31 August 2016

RE: SSD 7081 – Faculty of Arts and Social Sciences, University of Sydney

I refer to your invitation to comment on SSD 7081 for the proposed construction of the new Faculty of Arts and Social Sciences (FASS) Building and alterations to the RD Watts Building within Sydney University.

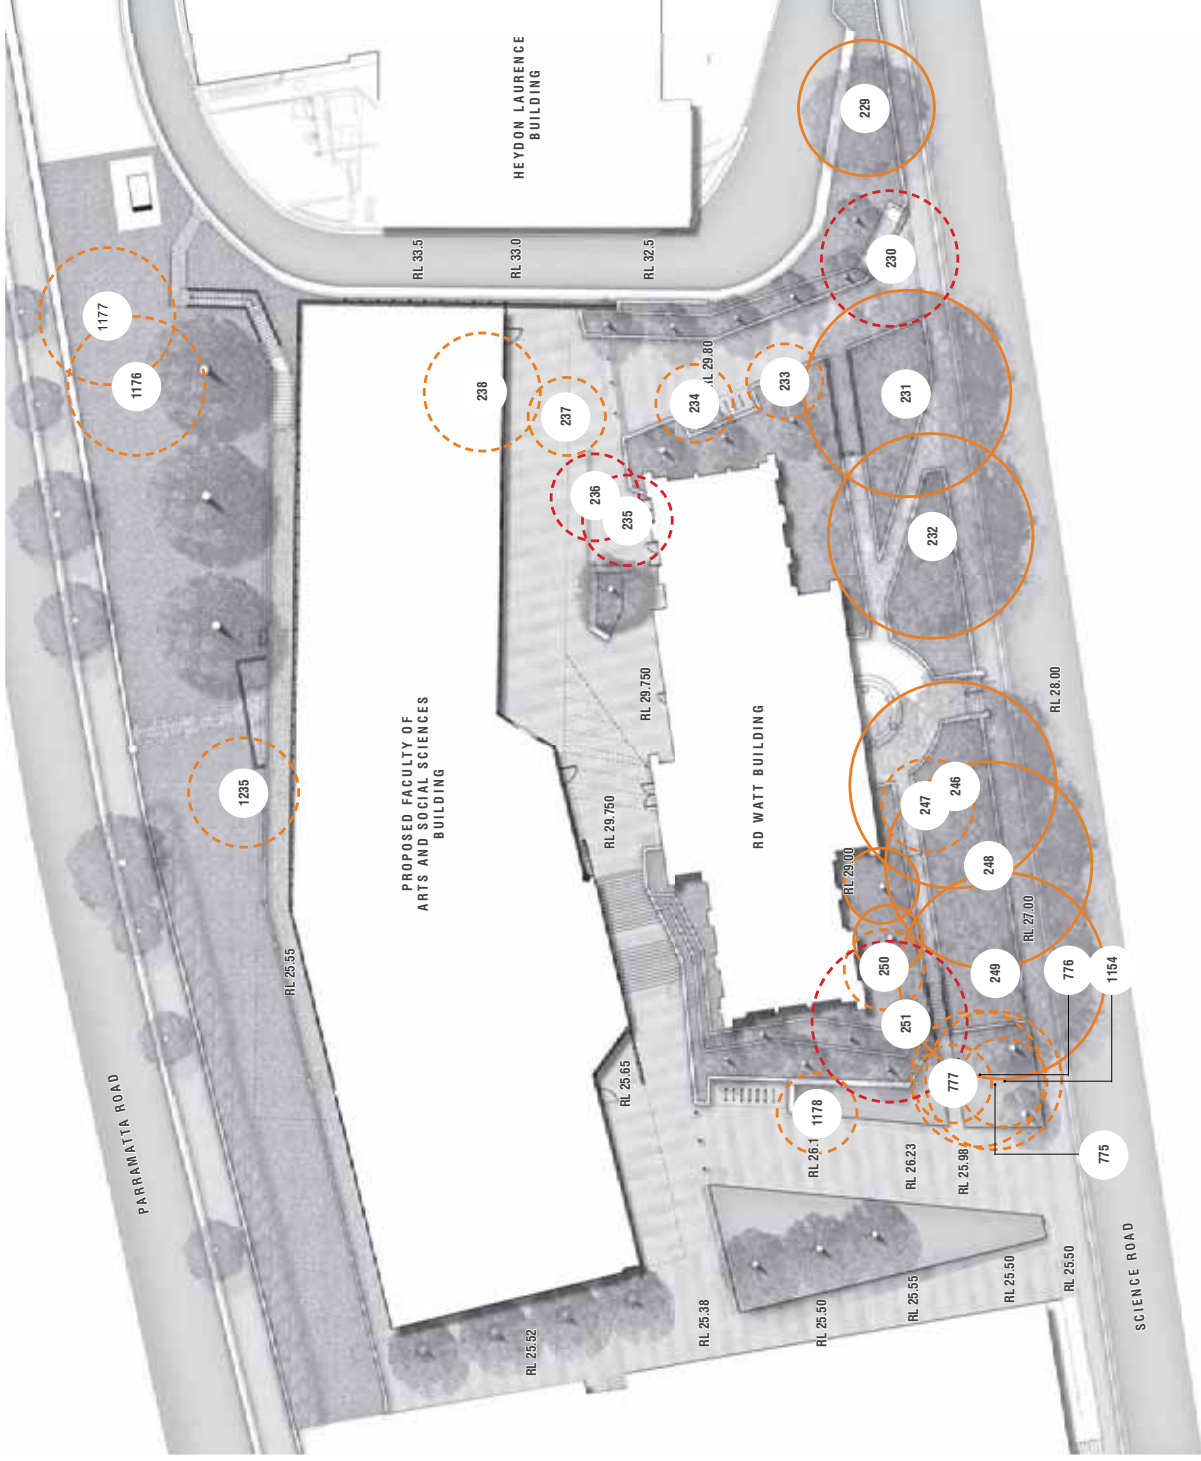
The traffic report provided by GTA notes that the proposal will accommodate up to 258 staff and 842 students/others (1,100 in total). The proposal is to provide 36 new bicycle parking spaces for the development. This is an underestimation of the cycling facilities required for the site. Applying the rates applicable within Sydney Development Control Plan 2012, the provision of 1 bicycle space per 10 staff and

students is appropriate. The provision of an additional 26 staff bicycle spaces and 85 student bicycle spaces should be considered as a minimum.

The staff bicycle parking should be class 2 facilities (known as Class 'B' in the latest Australian Standards) and provided as per AS2890.3:2015, and be located at an accessible at-grade location in a separate location to the visitor parking area.

Student parking might be class 3 facilities (known as Class 'C' in the latest Australian Standards) and provided as per AS2890.3:2015 and be provided at an accessible at-grade location. However, given the ability to provide students with swipe card access, the City would encourage predominately class 2 facilities.

FASS - UNIVERSITY OF SYDNEY  
LANDSCAPE SECTIONS

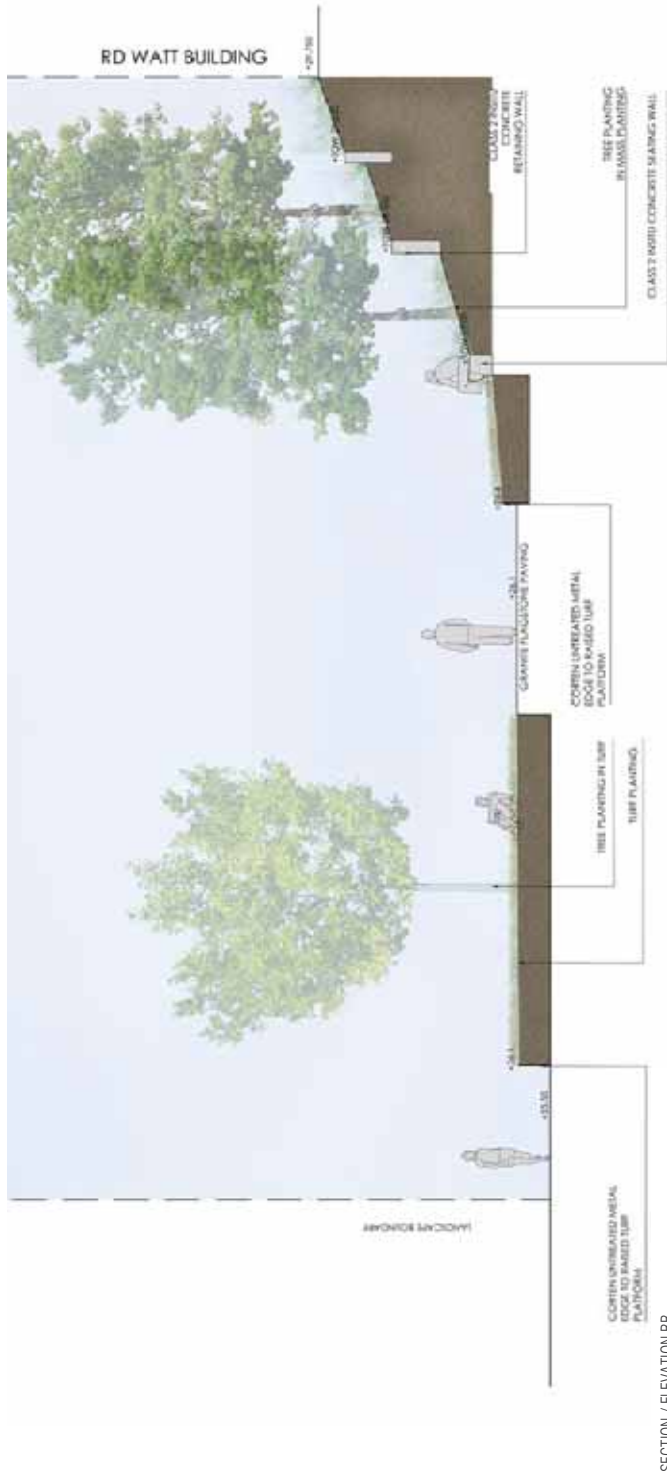
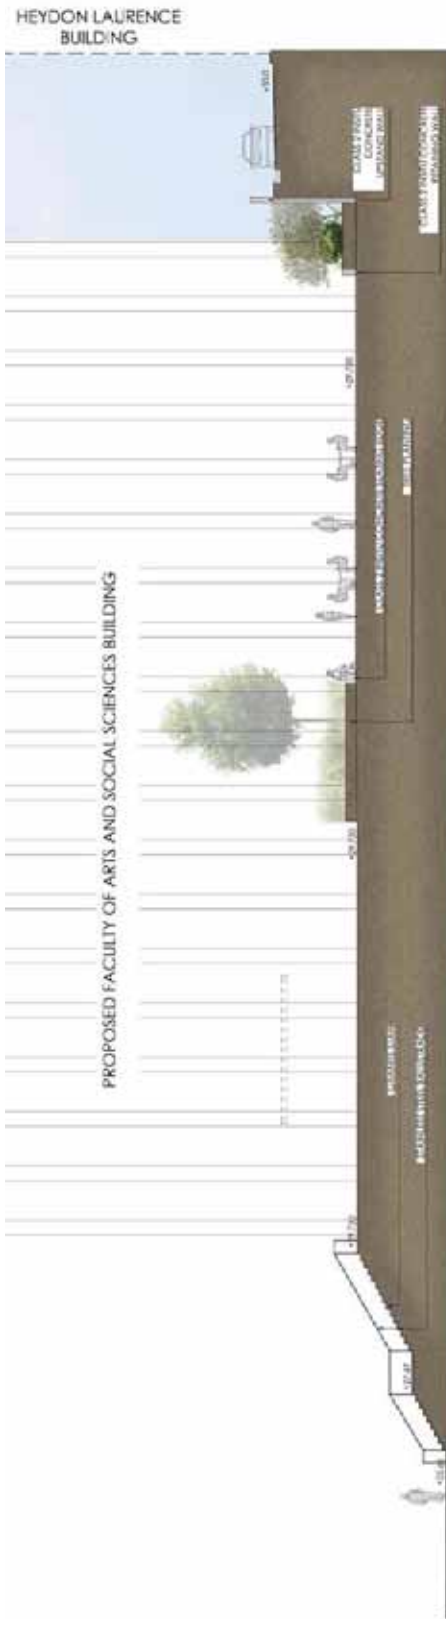
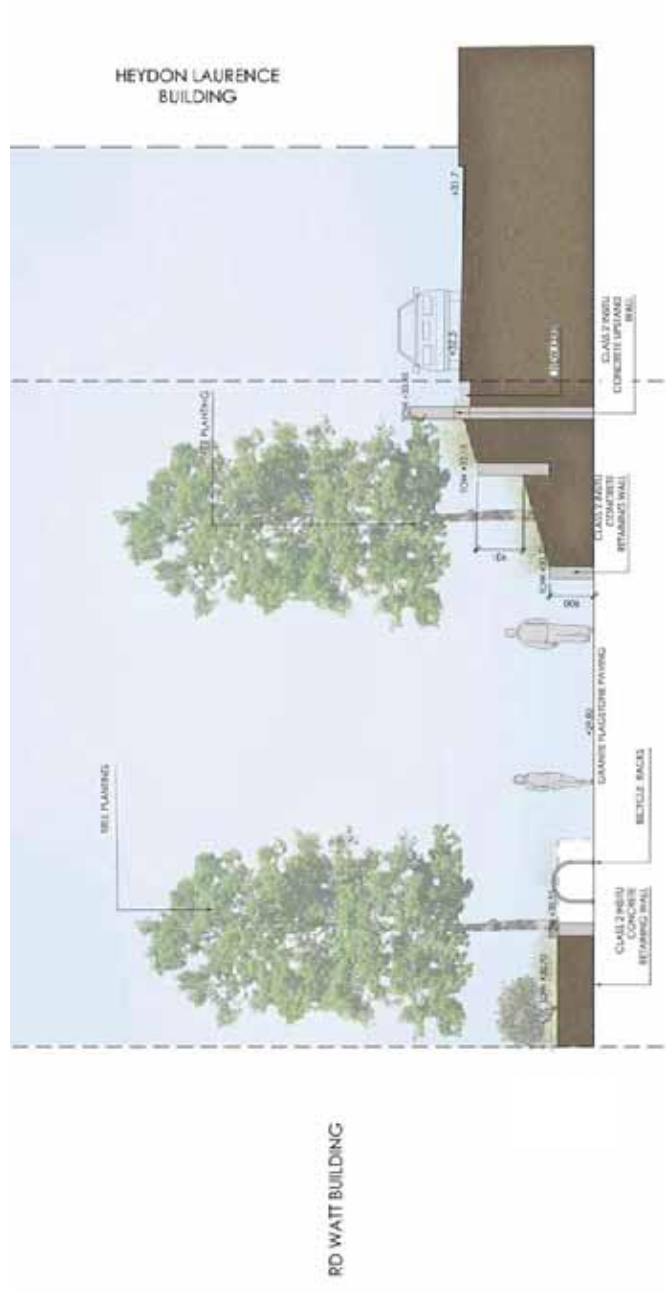
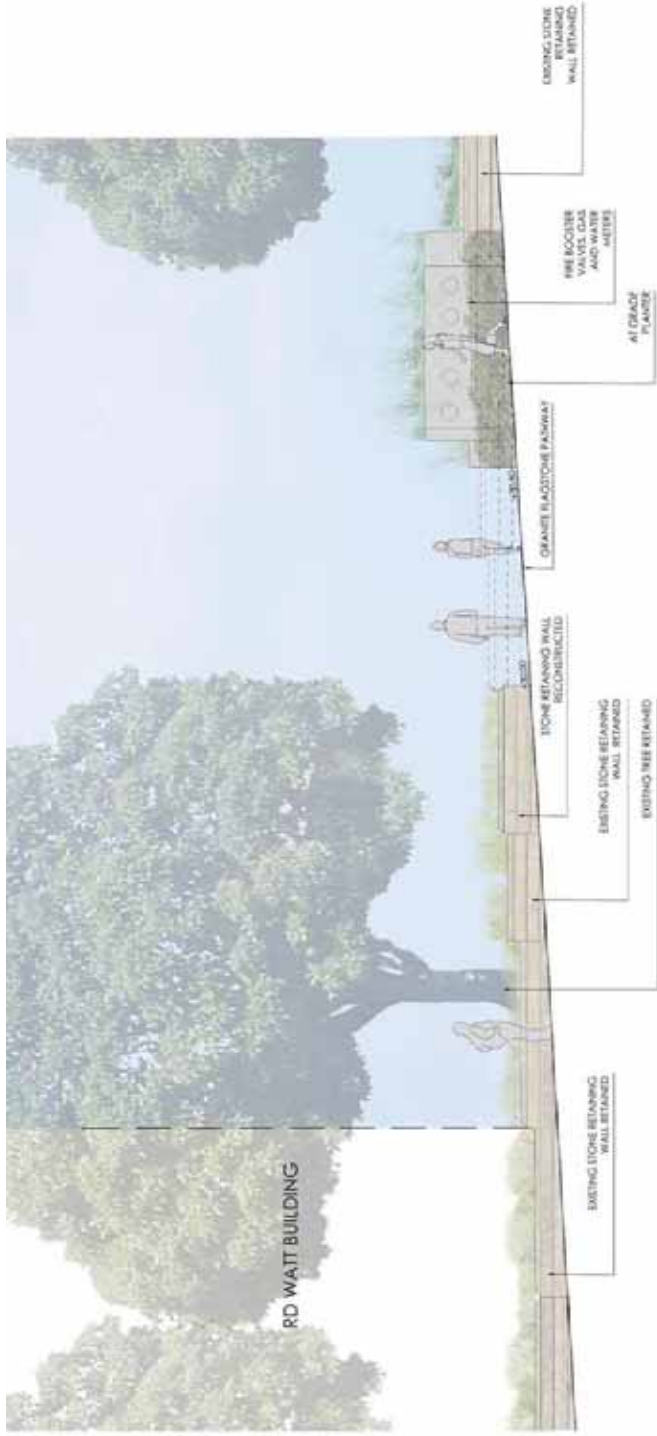
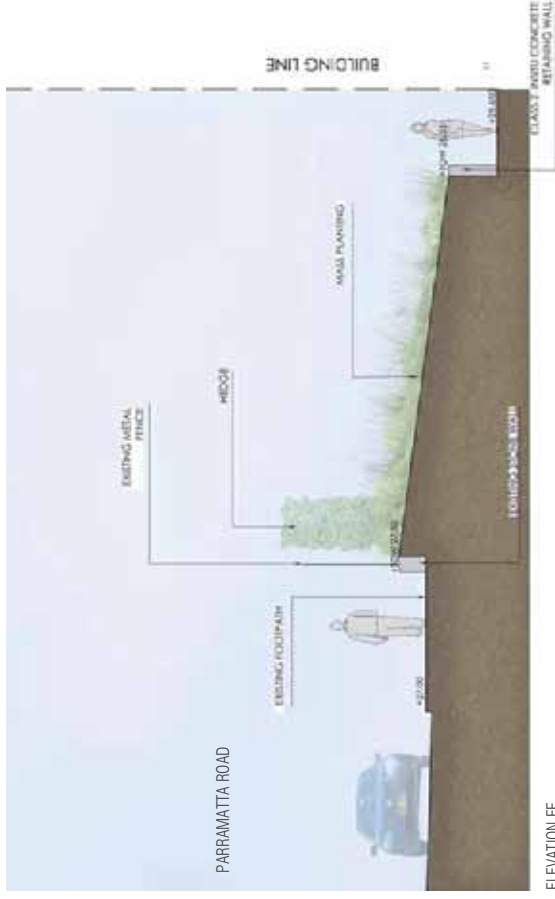
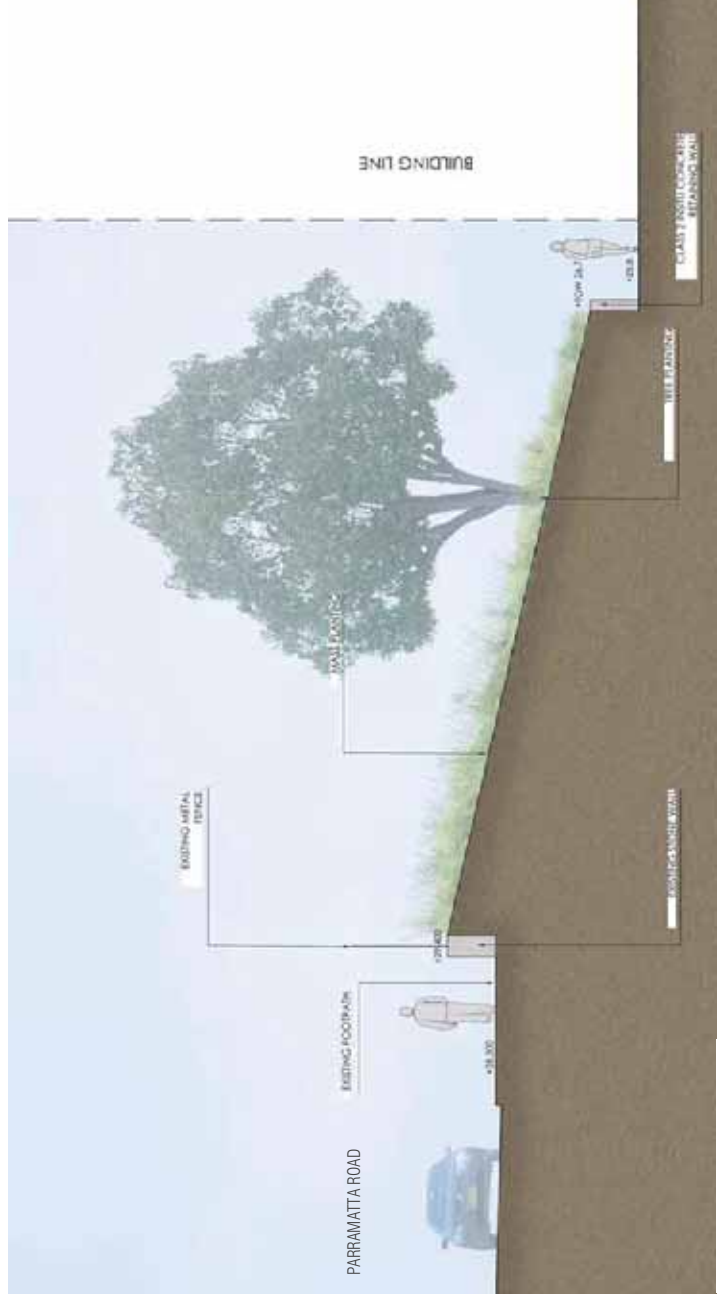
Heydon-Lawrence Road to the east reaches levels of approximately 3m higher than the front courtyard to Level 2 of the proposed FASS Building.

The scope of works under the SSD DA are unclear, however, it seems there is an opportunity to improve the level change between the road and the site. The current proposal appears to be limited to some awkward terraces and a 3m high wall.

Further resolution is required to the interface with Heydon-Lawrence Road to the east, to ensure the level changes are well integrated into the landscape design, and that welcoming, safe spaces are created between buildings.
